Berry, Huff, McDonald, Milligan Inc.
Engineers, Surveyors

May 30, 2014

RE: Level I-Minor Residential Development Review Site Plan Revisions
Single Family Lot
218 Washington Avenue – Melinda Schott
Tax Map 10, Block A, Lot 15

**1** **SITE PLAN**

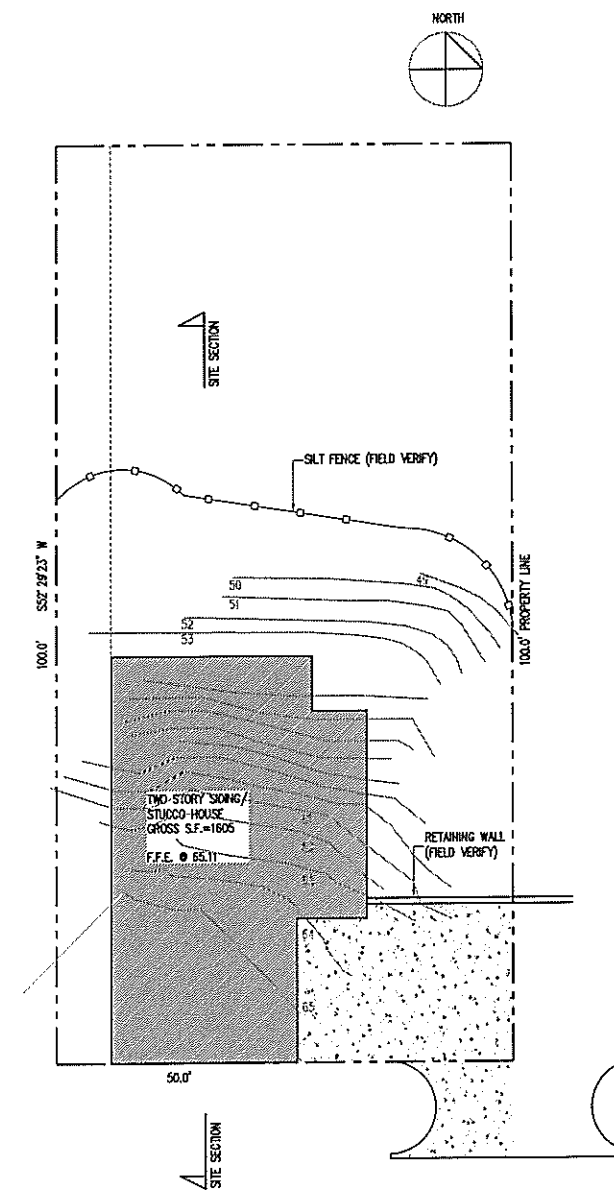
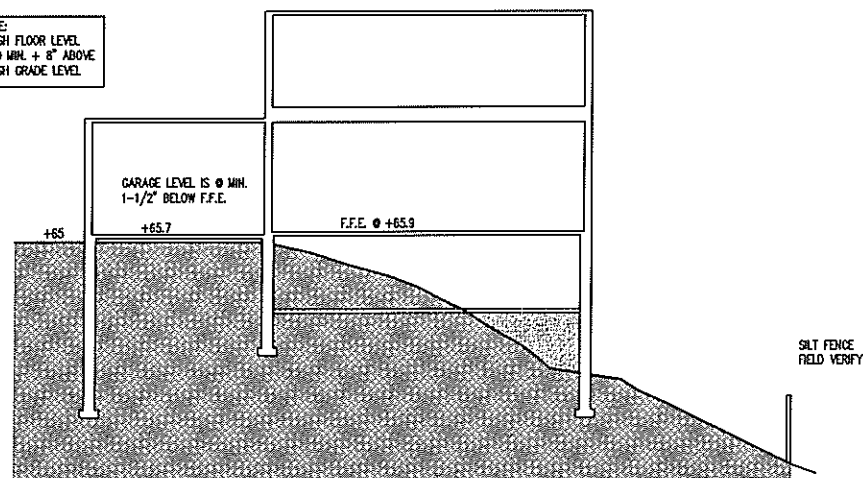
These revisions are based on comments from your office dated May 2 and May 5, 2014 in an email. The following is our response to these comments:

- Please find attached revised deed descriptions of the access easements with the language requested by the City Corporation Counsel.
- BH2M will be submitting a Level I Site Alteration Permit for Glenn Morse's Property today as well. Included within this application will be the retaining wall design by Structural Integrity. Now that Mr. Morse is moving forward with the Site Plan approval we hope that the City can issue a permit for Melinda Schott on her parcel of land since all of the outstanding issues have been addressed. Please note that the attached Site plan has been revised to incorporate site improvements for Glenn Morse's property.

- The soils onsite consist of Hollis fine sandy loam (HrB) per the Cumberland County Soil Survey. This soil is hydrological soil group c or d according to the Maine TR-55 manual from 1986. The permeability rate of this soils is described as 2 to 6.3 inches per hour within the Cumberland County Soil Survey. As currently designed the site has at least a 36-foot long meadow buffer on the

Southwesterly end of the property along the common boundary with the downhill abutters. All of the proposed parking areas direct the runoff to Washington Avenue. The only portion of the site directing runoff towards the abutters to the Southwest is the building which is approximately 1,235 s.f. in size (0.03 Ac.). The amount of runoff generated by this insignificant area is very minimal, in fact it is anticipated that very little runoff will actually exit the proposed roof drip edge system directing runoff to the Southwestern portions of the site. These very insignificant flows will be discharged in sheet flow over the 36-foot wide meadow buffer where all of the runoff will infiltrate into the ground at 2 to 6.3 inches per hour and create no adverse impacts to the abutting parcels or any downhill conditions. Please note that the negative easement along the Southwestern portions of the site will require this area to remain undeveloped and thus a meadow buffer.
